DECISION DELEGATED TO HEAD OF PLANNING

Application No:	H14-0893-22	Applicant:	Anglia (UK) Ltd.
Proposal:	Details of scheme to deal with external materials, design & position of external meter boxes, gas flues & soil vent pipes, existing & proposed site levels & proposed floor levels and means of foul & surface water disposal (Conditions 4, 5, 7 & 9 of H14-0295-22)		
Location:	The Anglia Business Centre Mill Green Road Pinchbeck		
Terminal Date:	18th December 2023

Drawing Title
Drainage Areas

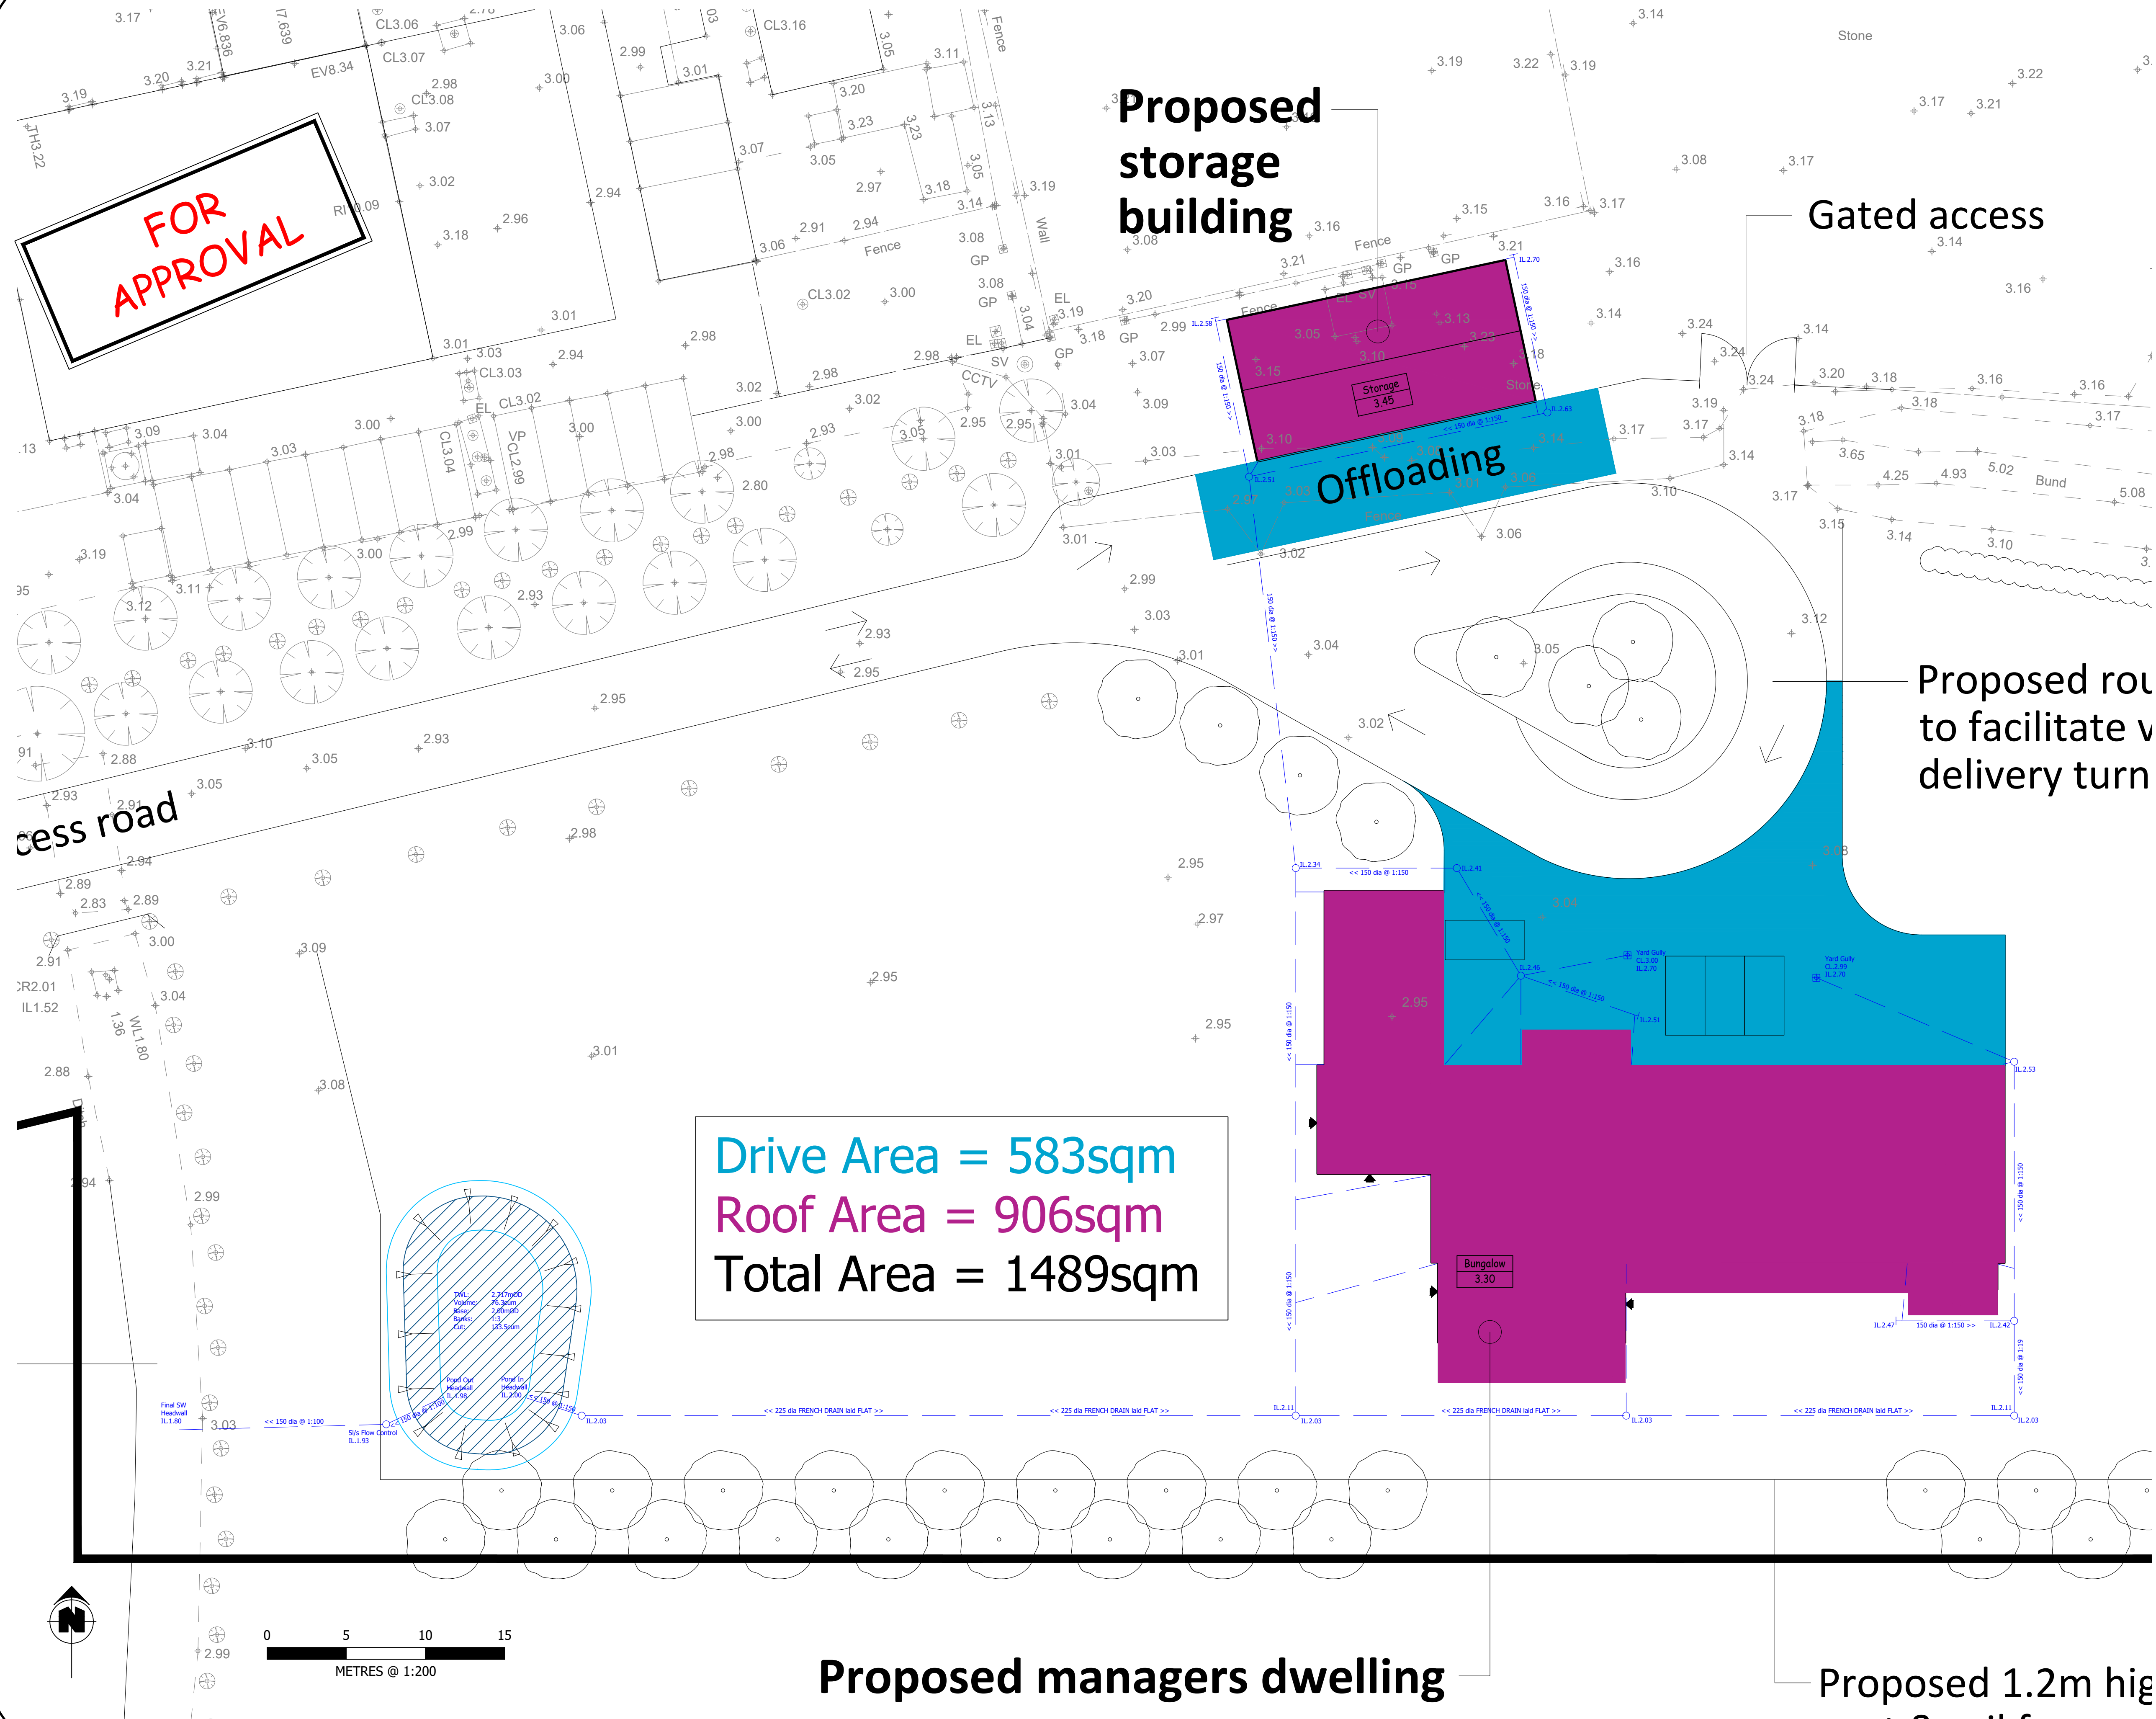
The submitted Drainage Layout plan states: "Manager's dwelling to discharge to new gravity pipework and taken to a new foul water pumping station. The pumping station will deliver the flow to the existing sewage treatment plant on the southern site boundary. Proposed storage building and manager's dwelling plus parking area to discharge to the existing watercourse using a controlled 5l/s discharge rate with an attenuation pond sized to capture run off up to a 100yr + 40% climate change event.

The proposed foul water and surface water are considered to be appropriate for the site and should not materially impact capacity elsewhere in the system.
